**FINAL DRAINAGE REPORT  
FOR  
ESTATES AT CATHEDRAL PINES  
EARLY GRADING,  
EL PASO COUNTY, COLORADO  
PCD File No. EGP232**

November 2023

**JR ENGINEERING**  
5475 Tech Center Drive  
Colorado Springs, CO 80919  
(719) 593-2593

# ESTATES AT CATHEDRAL PINES PROPOSED DRAINAGE MAP

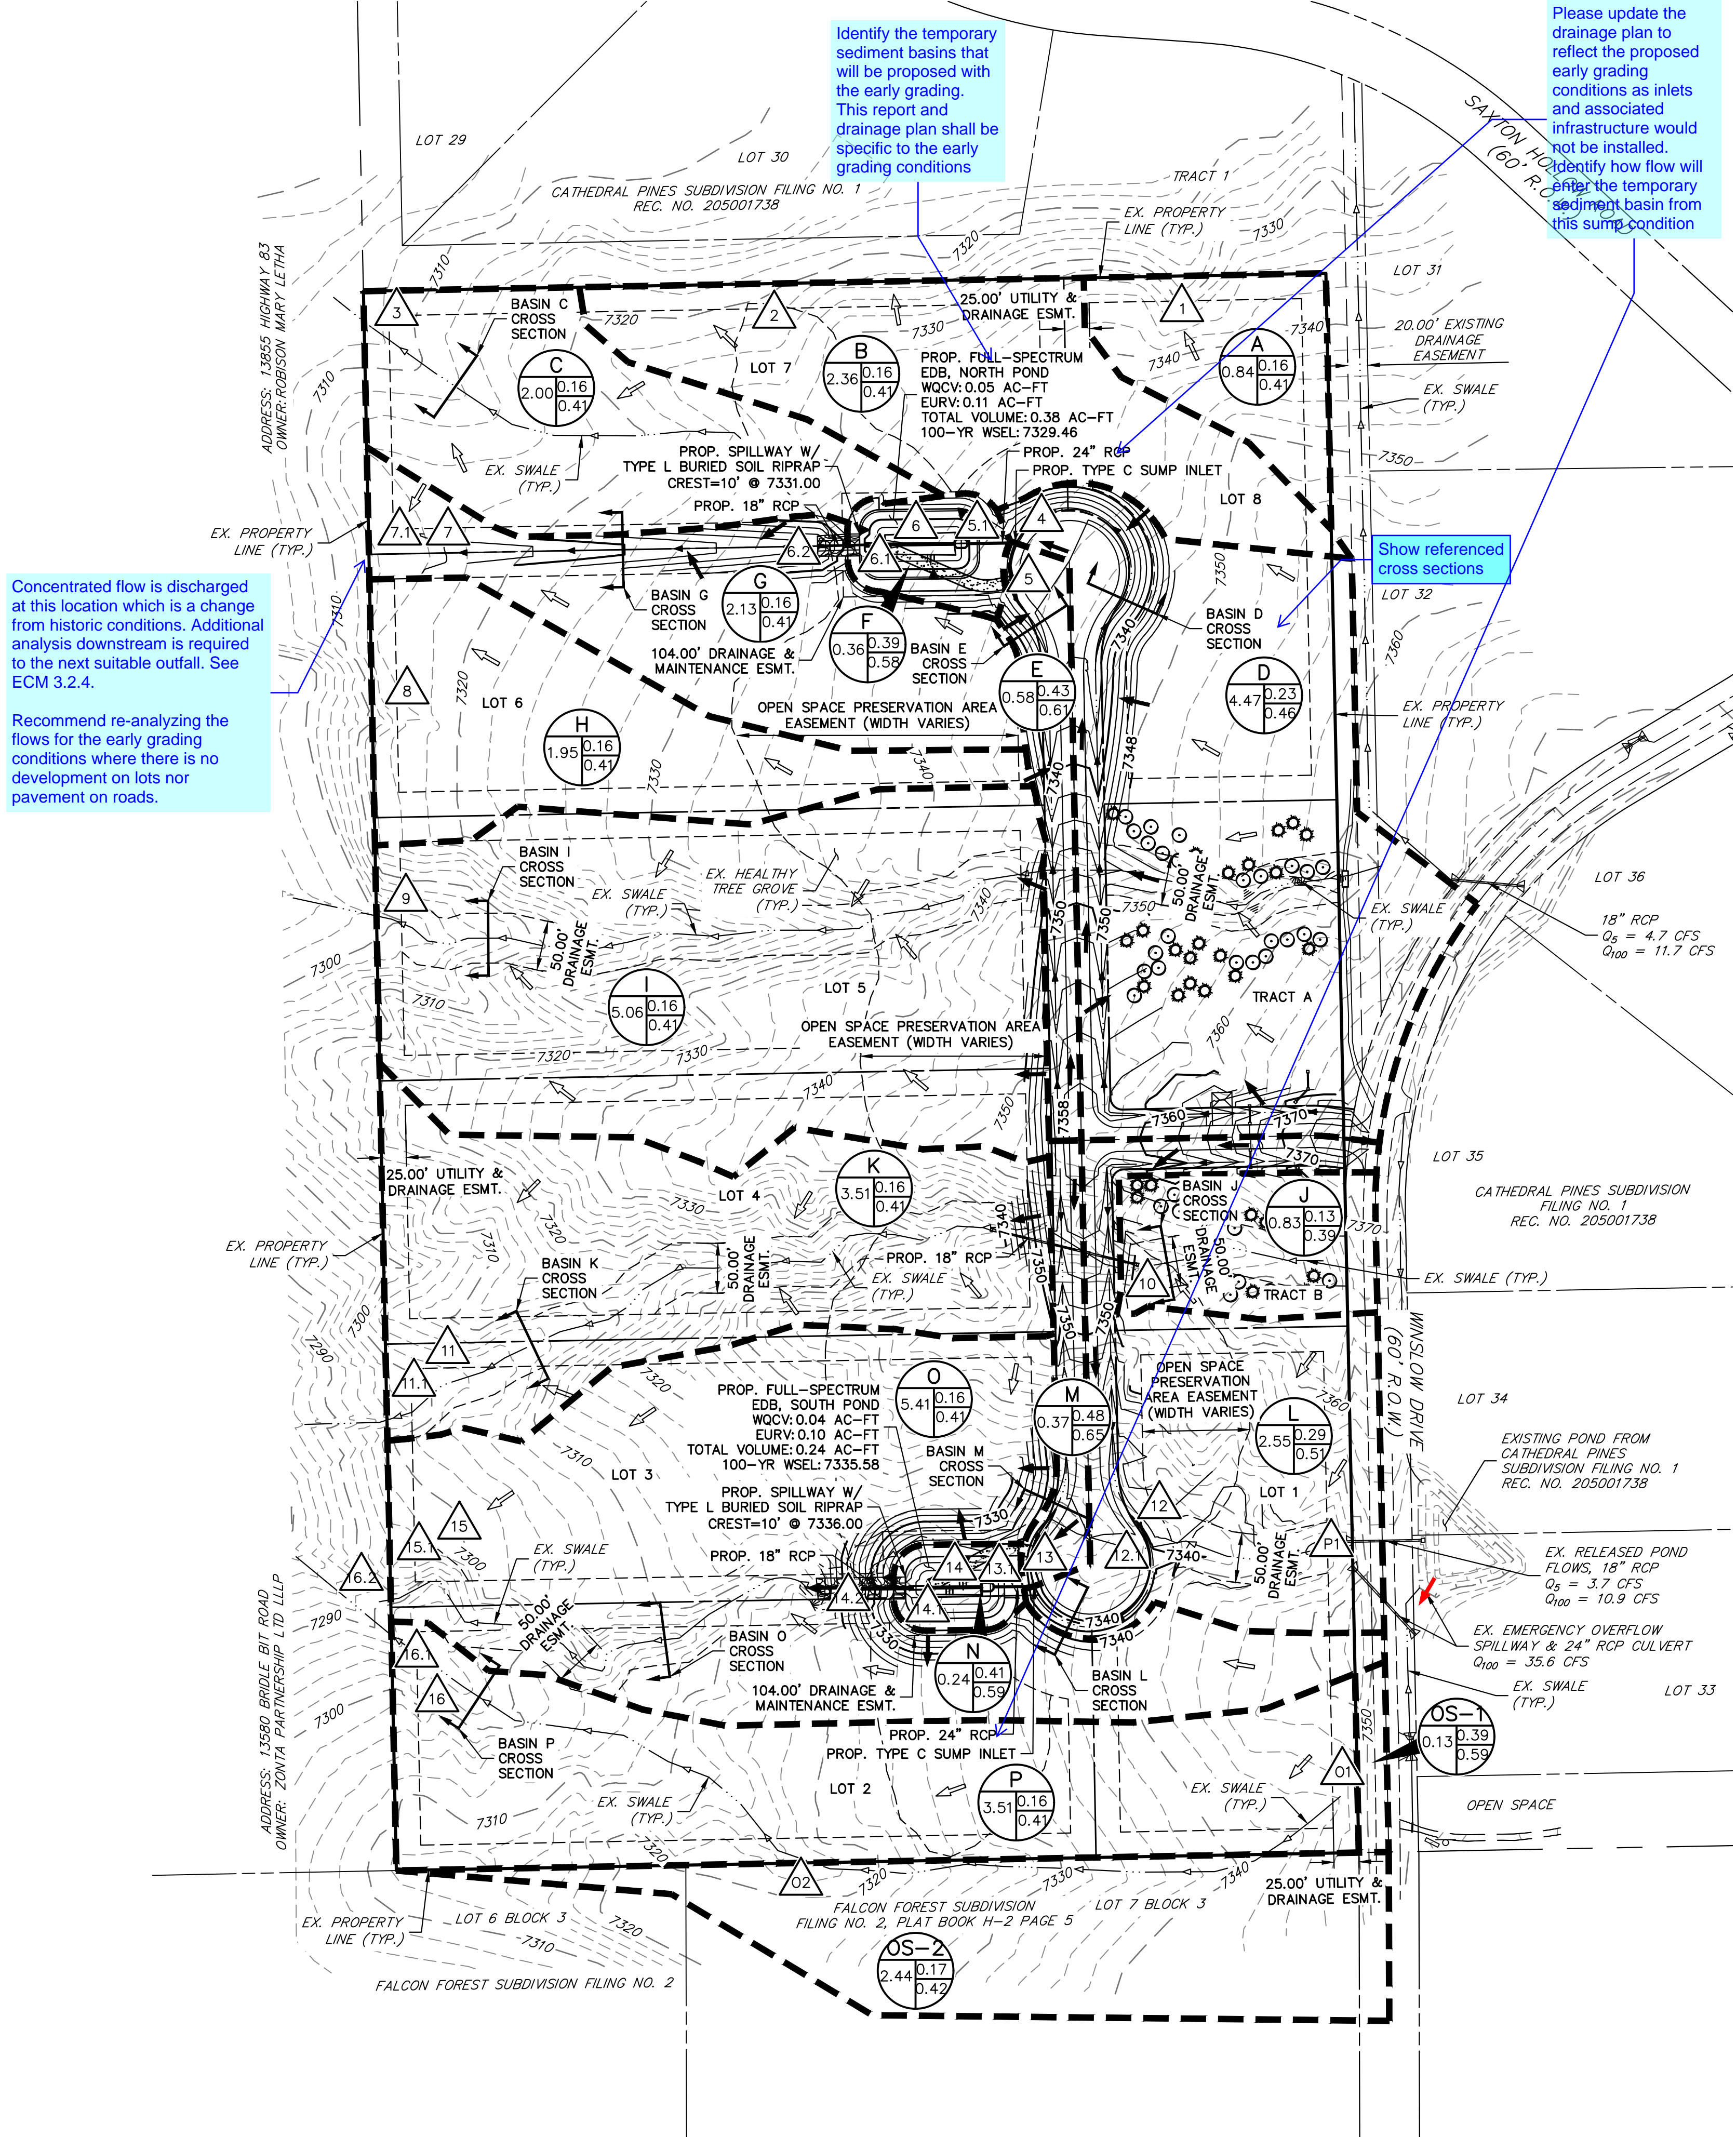
how did we determine this flow?

Please resolve.

**JR Response:** Added statement describing where the flows came from
